Subject: Planning Application 3/2024/0552

Re: Futher concerns re: Planning Application 3/2024/0552 - Property on Bawdlands

Client: Boutique Homes Ltd		
Project: Proposed Alterations 27-29 Bawdlands Clitheroe		
Dwg title: Proposed Rear Elevation		
Scale @ A3: 1:50	Date: 05.06.24	Drawn by: PD
Drawing no. 1569 - 1 - 12		Rev. B

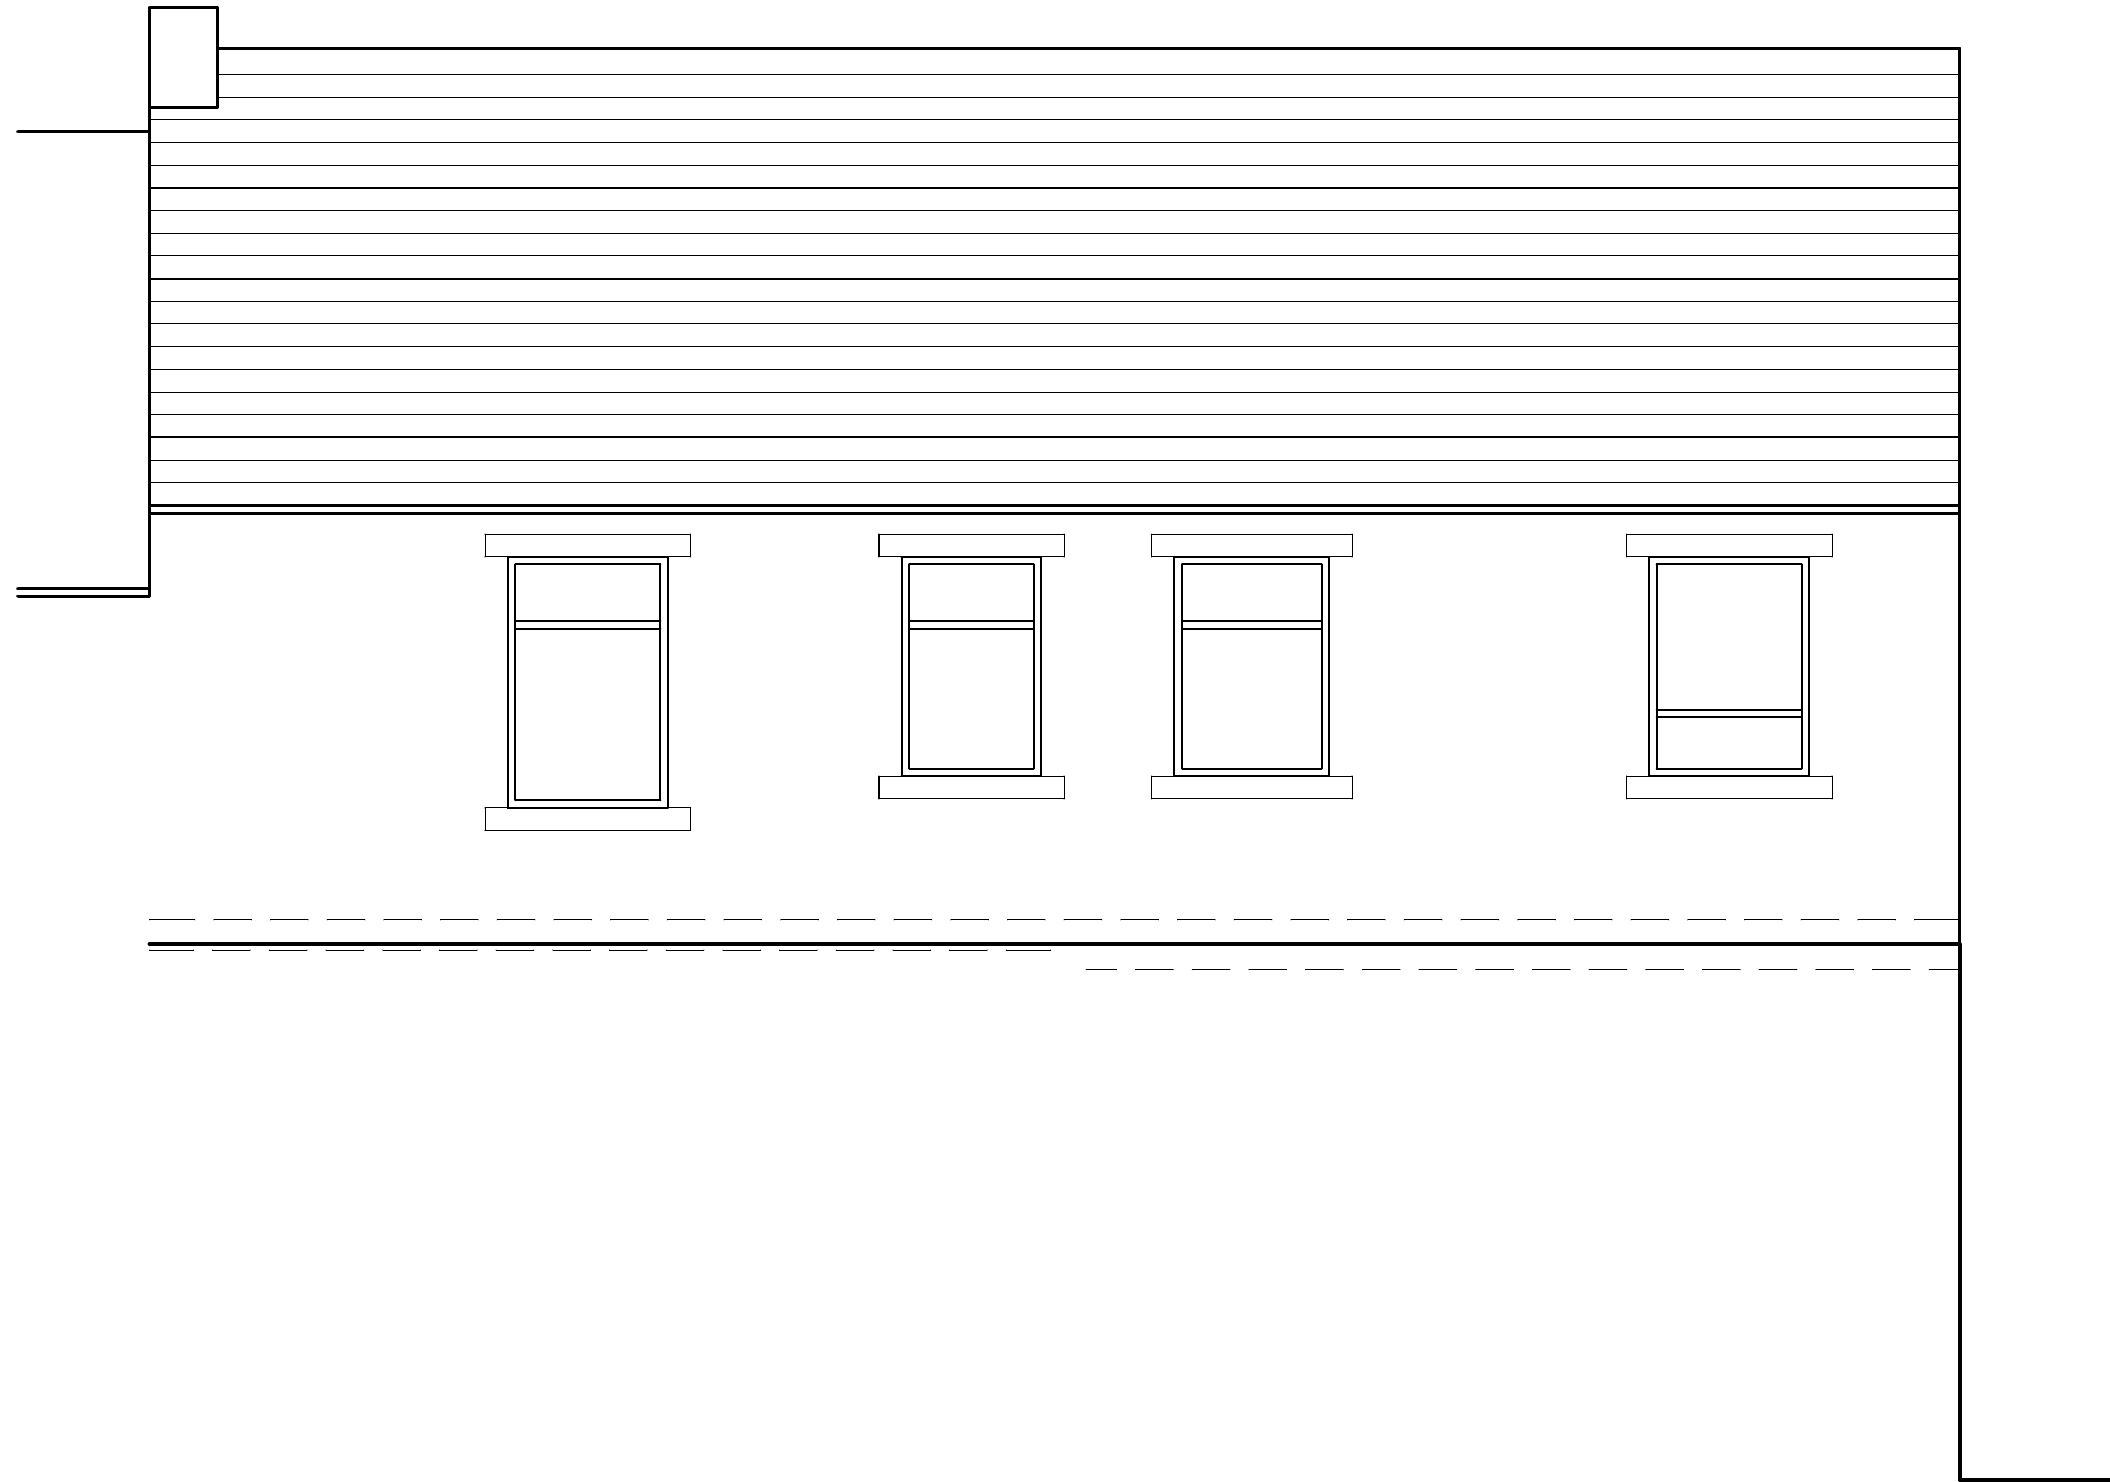
Moreover, the proposed bicycle parking area at the rear of the property does not appear to be large enough to accommodate the eight bicycles as suggested. This raises further doubts about the feasibility of the proposed parking solutions.
